The Sizewell C Project, Ref. EN010012

Comments on any additional information/submissions received at D7

Suffolk County Council Registration ID Number: 20026012

Deadline 8

Plate 3.5: Site plan showing Water Management Zone catchment areas

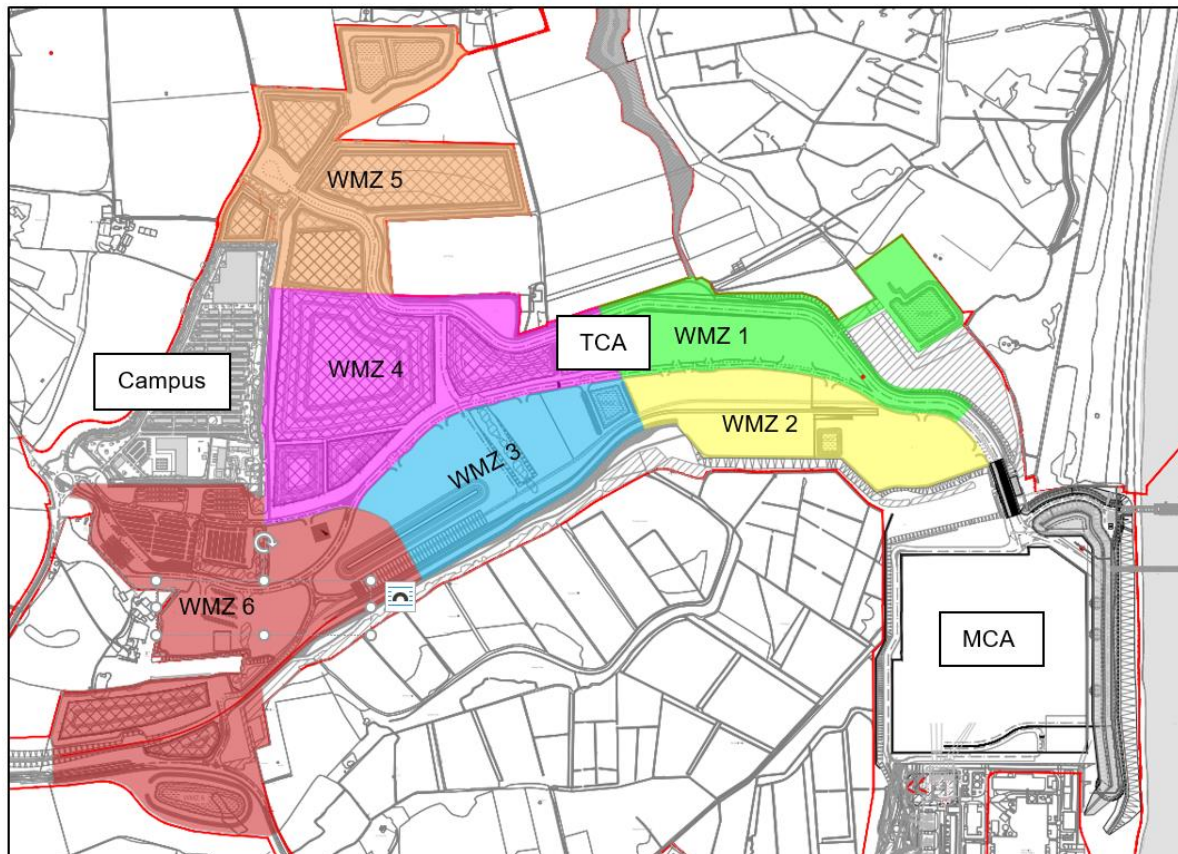
3.3.20	The site entrance hub will follow the same guidelines as laid out in this Drainage Strategy.	Figure 2A.4, appended to this document suggests that the site entrance hub is included within the catchment of WMZ6. This is also supported by the MDS WMZ Technical Note [REP5-120, Appendix D]. Also supported by Plate 3.5 of this document.

Plate 4.3: Freight Management Facility

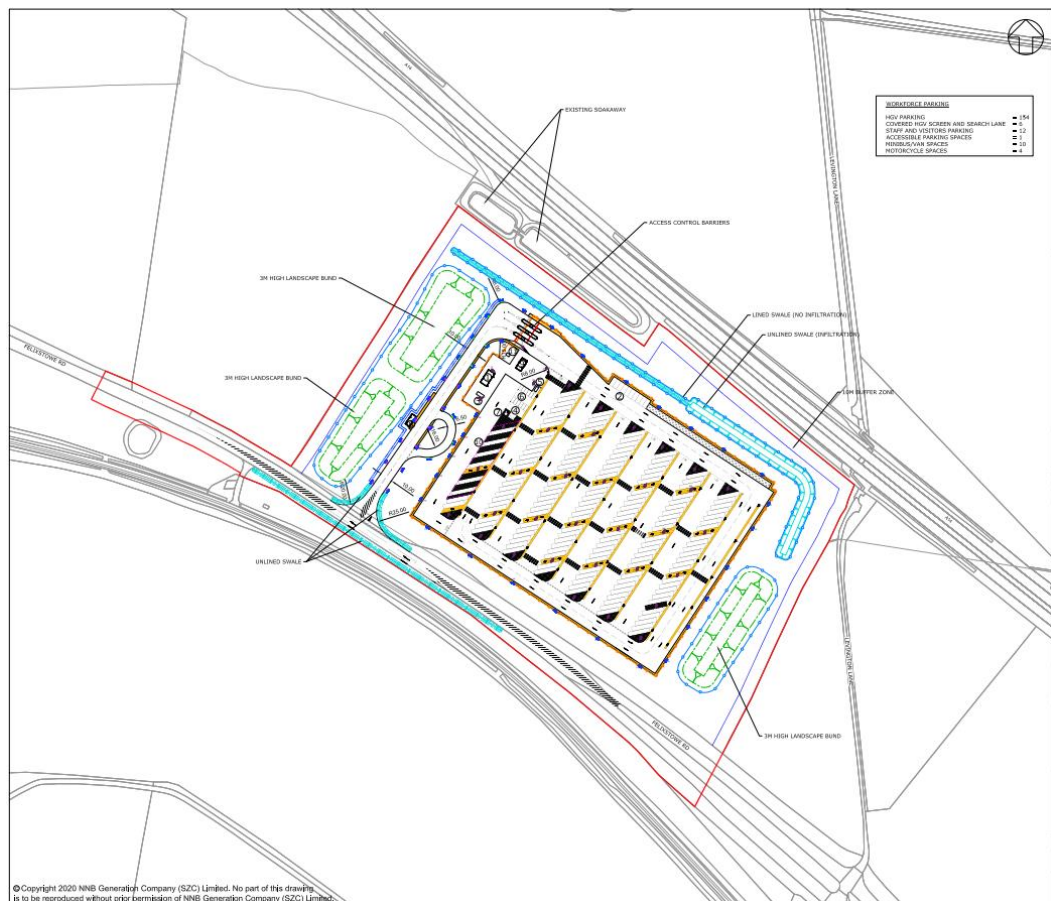
6.1.3	All of the internal roads and the HGV parking areas will have an impermeable surface. Surface water runoff will be drained via surface outlets, gullies, linear channels and drains, etc. These will discharge into underground carrier drains.	If all internal roads are proposed to be impermeable, drained by traditional drainage, directly into the crated system, where is adequate treatment of the surface water being provided for a site that is assigned a high pollution hazard level using the CIRIA SuDS Manual Simple Index Approach?

6.1.5	The concept design submitted for DCO and shown in Plate 1 provided for underground carrier drains which will discharge all surface water runoff into two underground attenuation storage tanks from where it will infiltrate to ground. The tanks are proposed to be located beneath the landscape bunds located on the east and west sides of the site.	<p>All attenuation for this site is proposed in a below ground crated system. This approach does not comply with the following documents due to the lack of pollution treatment, biodiversity and amenity benefits associated with such an approach:</p> <ul style="list-style-type: none"> • Local Plan Policy SCLP 9.6, particular attention drawn to paragraph 9.59 • Local Guidance - Suffolk County Council Flood Risk Management Strategy, Appendix A • National Guidance - CIRIA SuDS Manual <p>The infiltration rate is stated as an average of the values obtained through testing. As per BRE 365 methodology (paragraph 3.2.3), the lowest of the three test results should be used for design. Therefore, this</p>

<p>methodology and all subsequent information based on this result (including appended calculations) are not accepted by SCC.</p> <p>SCC made it clear in in East Suffolk Council & Suffolk County Councils Local Impact Report that a below ground attenuation solution was not supported [REP1-045 para 20.85].</p>
